SITE PLAN
DETACHED GARAGE
11712 FLAP JACK LANE
EL PASO COUNTY, CO
FOR: MASTERBILT HOMES

V1_Site Plan Drawing.pdf Markup Summary

SITE PLAN
DETACHED GARAGE
11712 FLAP JACK LANE
EL PASO COUNTY, CO
FOR: MASTERBILT HOMES

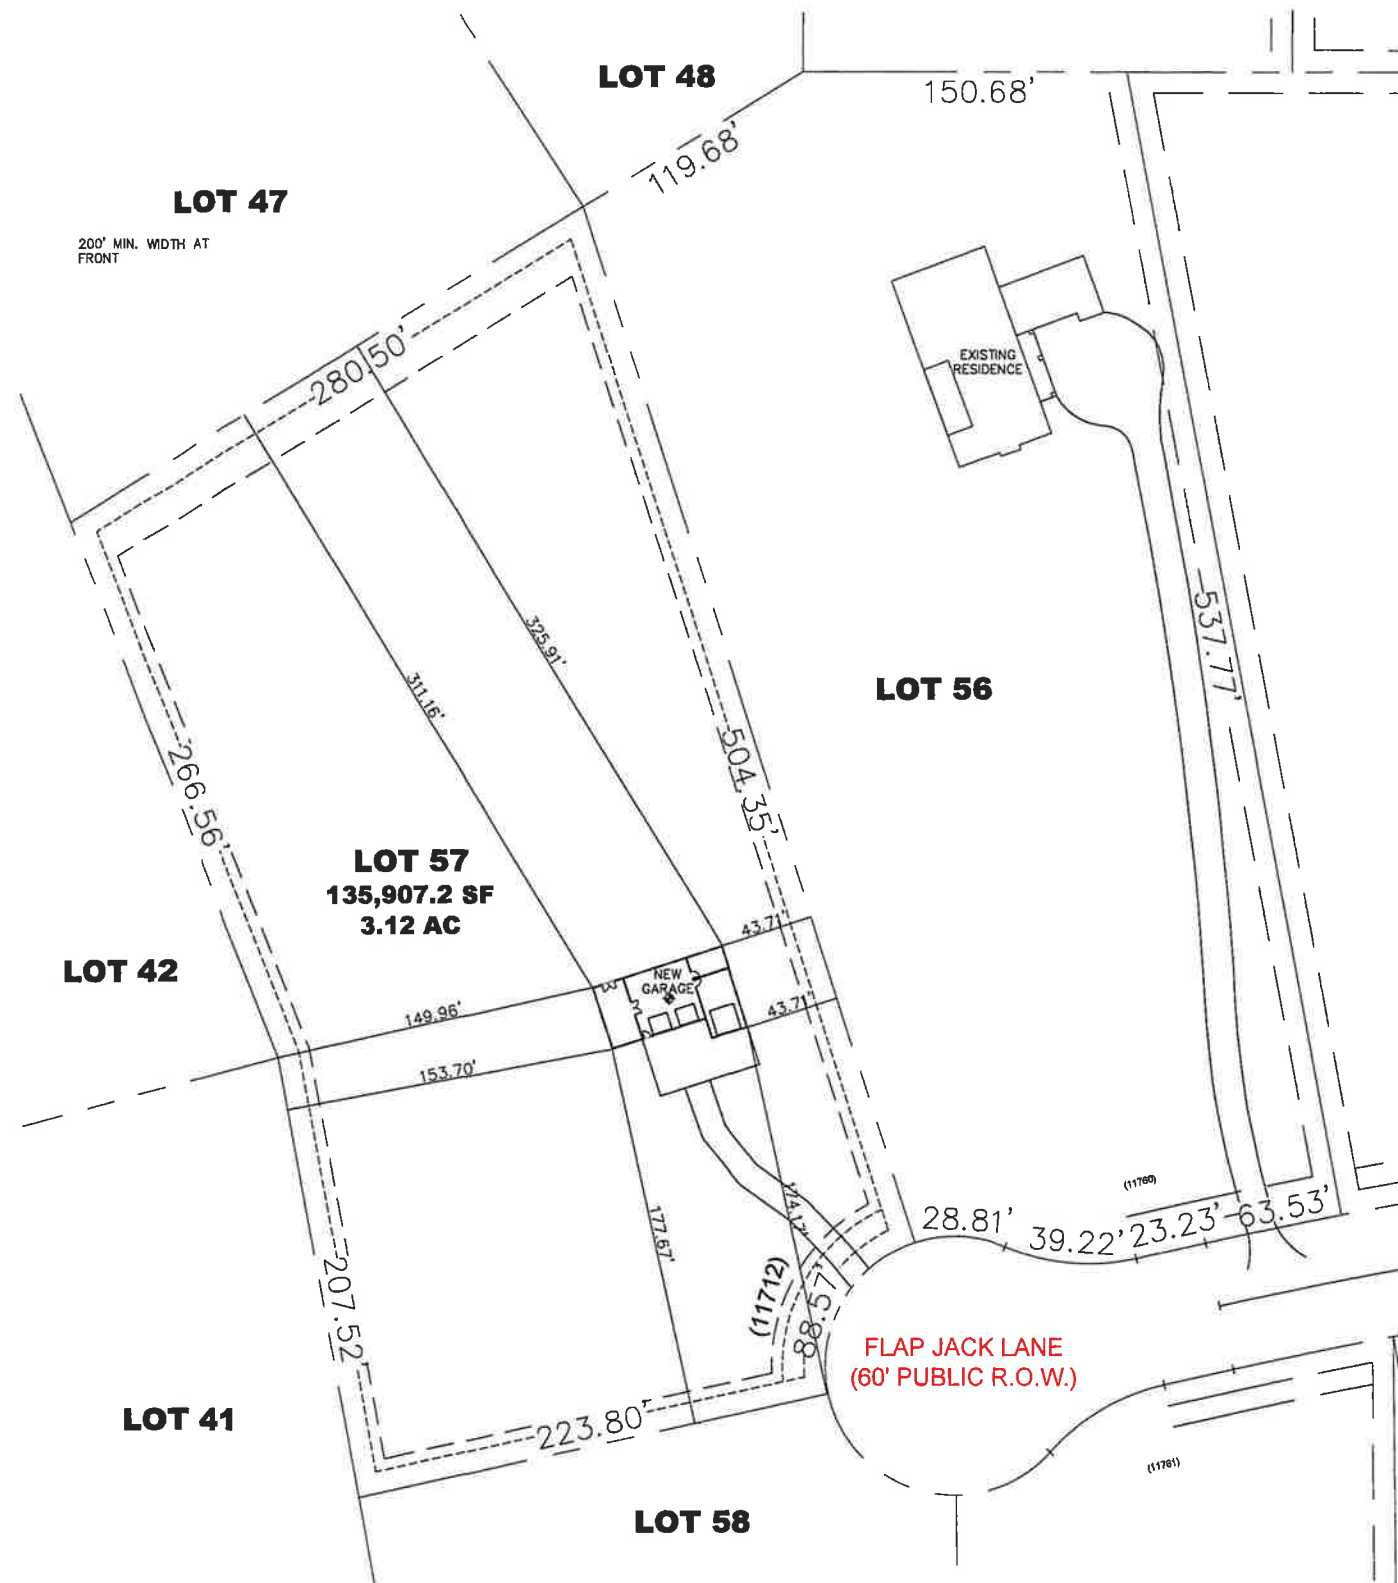
Please correct zoning to RR2.5

what are these 3 squares? please label

Please dimension building,
Please add surface of driveway and width.

Please add a note: Garage is for personal
residential use supporting Lot 56 only.

A driveway permit will be required
